April 28, 2003

Re: Project # 1002330/ Lots G-1 and G-2, Montgomery Complex

Site Plan for Subdivision
MONTGOMERY COMPLEX

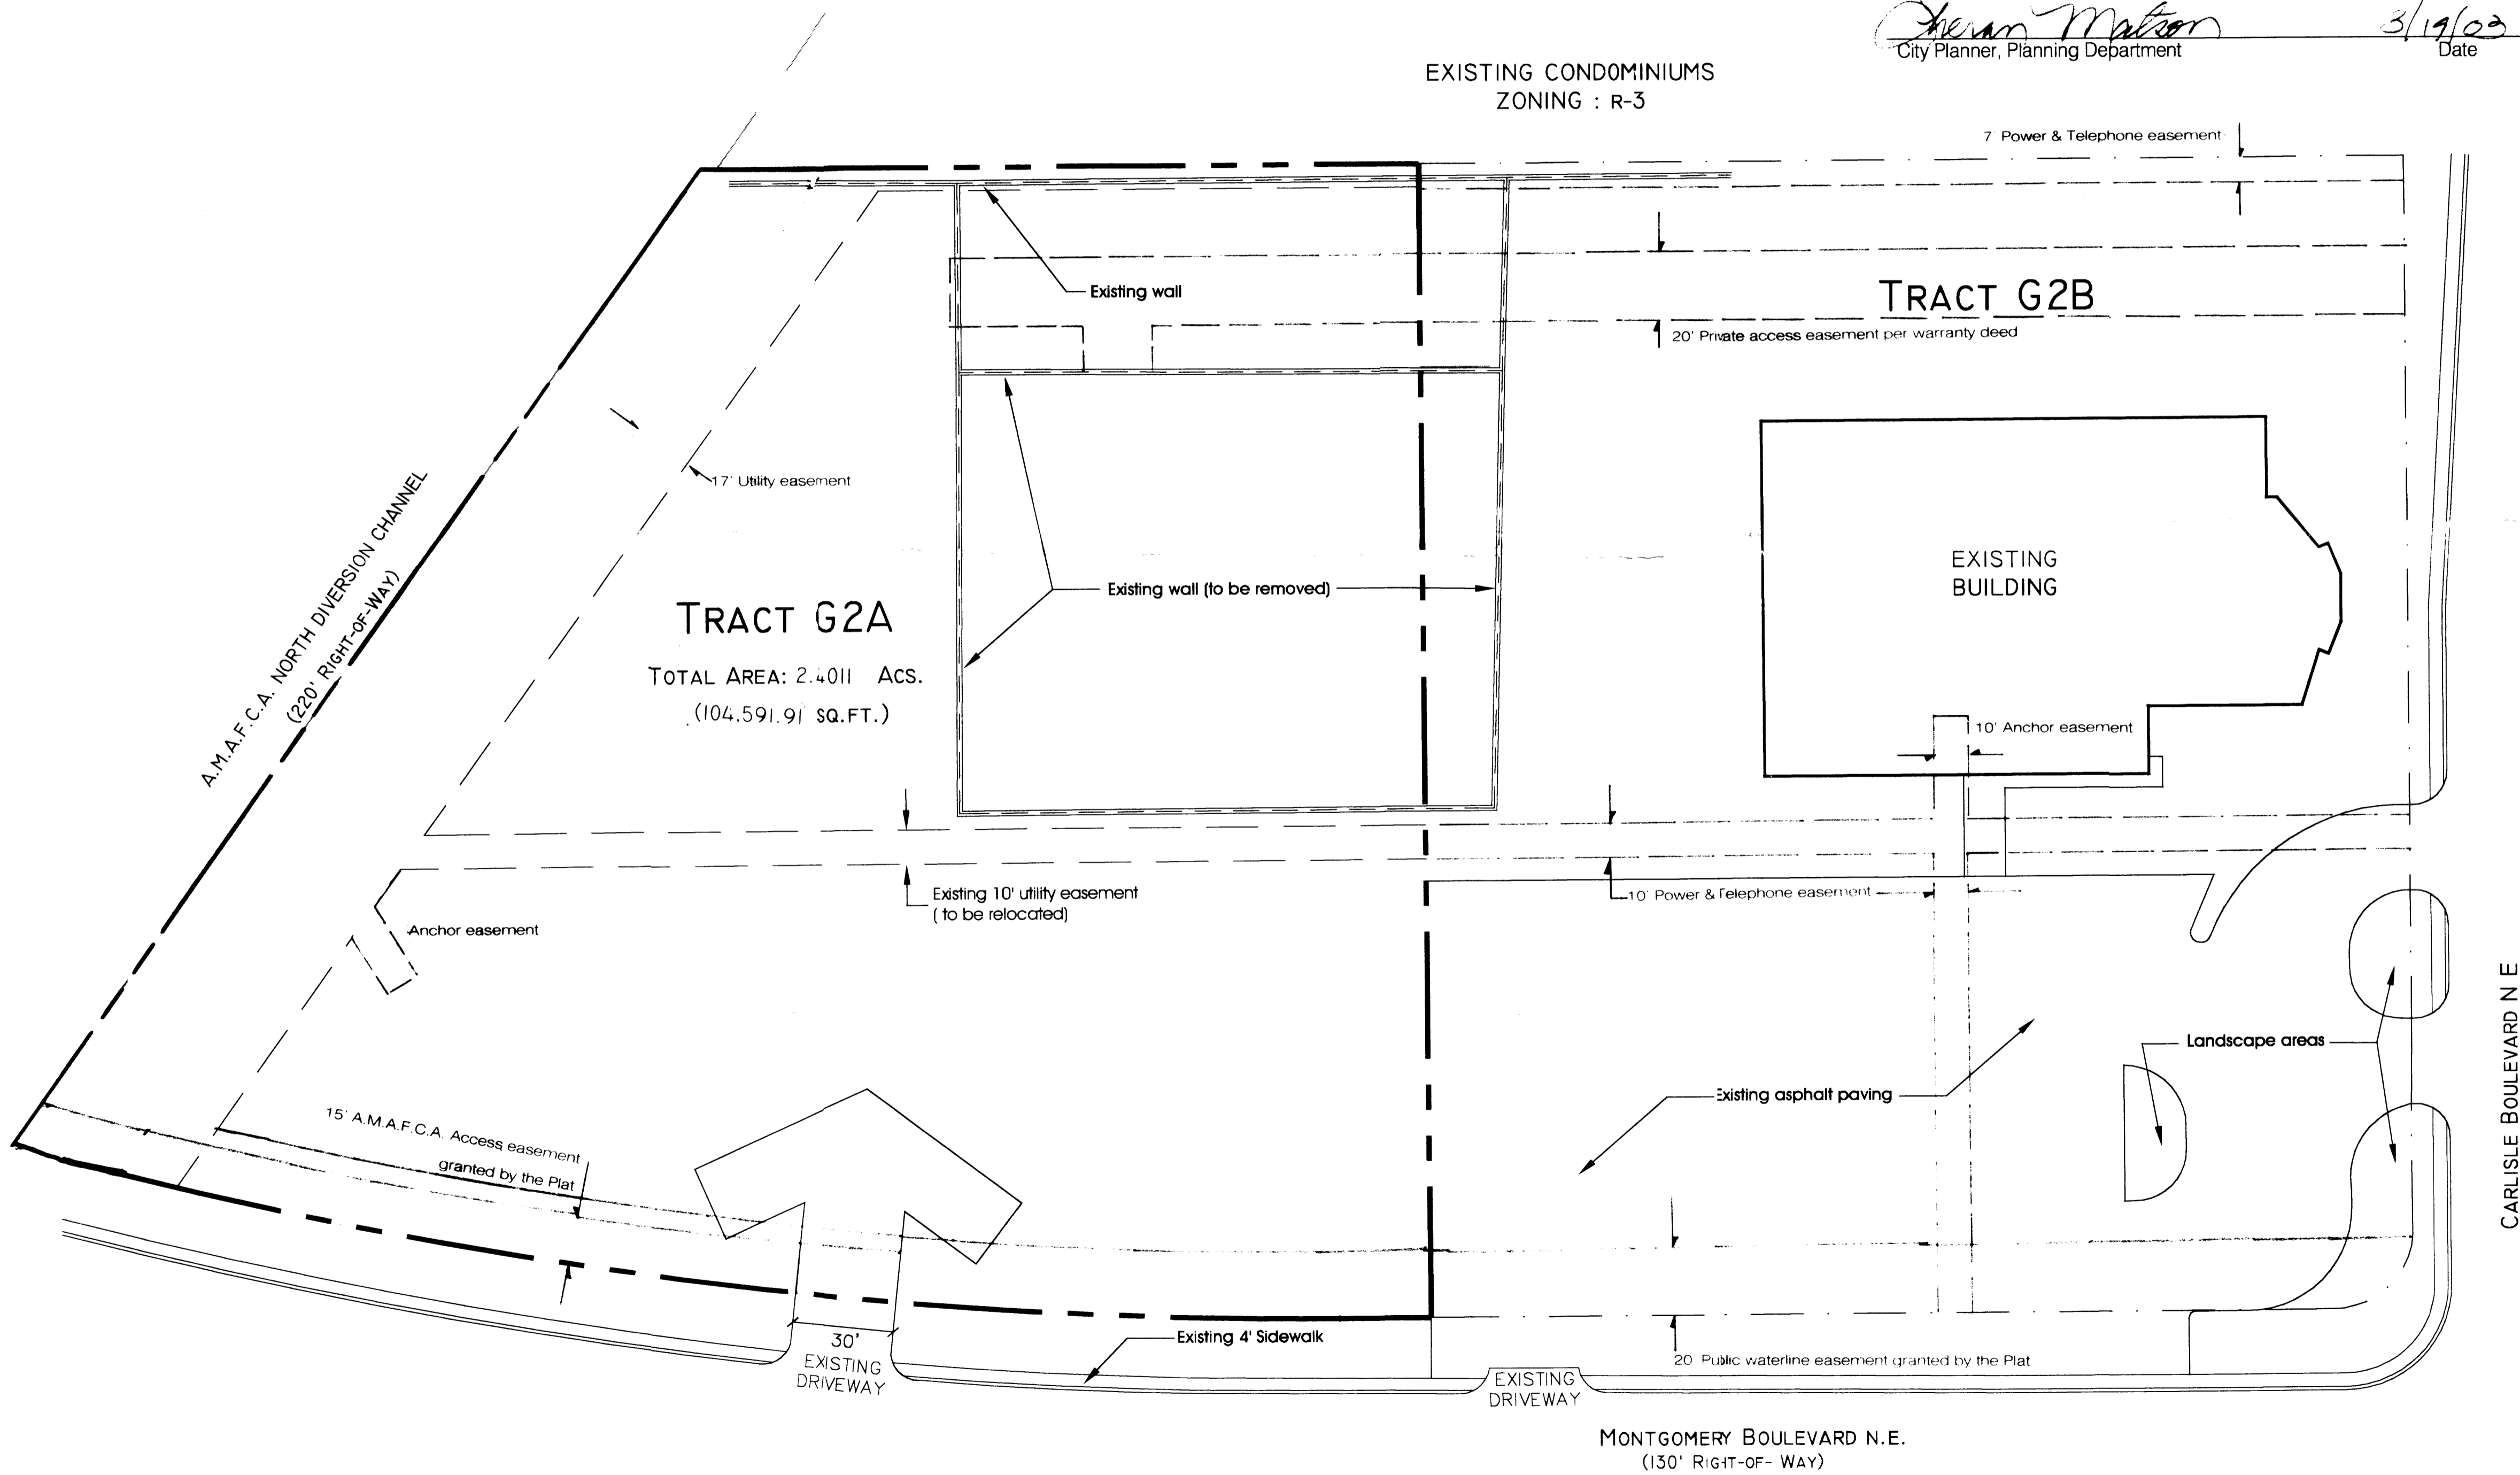
The purpose of this letter is to inform you that we would like to replace the signed site plan for the above referenced property. As we discussed last week, the reason is that we discovered the western property boundary on the site plan did not match the recorded plat. As a result, the acreage on the site plan also did not reflect the actual acreage of the property. We have corrected the western property boundary and corrected the acreage from 2.2 acres to 2.4 acres. I have included three bluelines of the Site Development Plan for Subdivision. Please replace the three that were previously turned in. Please feel free to call me at 764-9801 if you have any questions or need additional information. Thank you for your assistance in this matter.
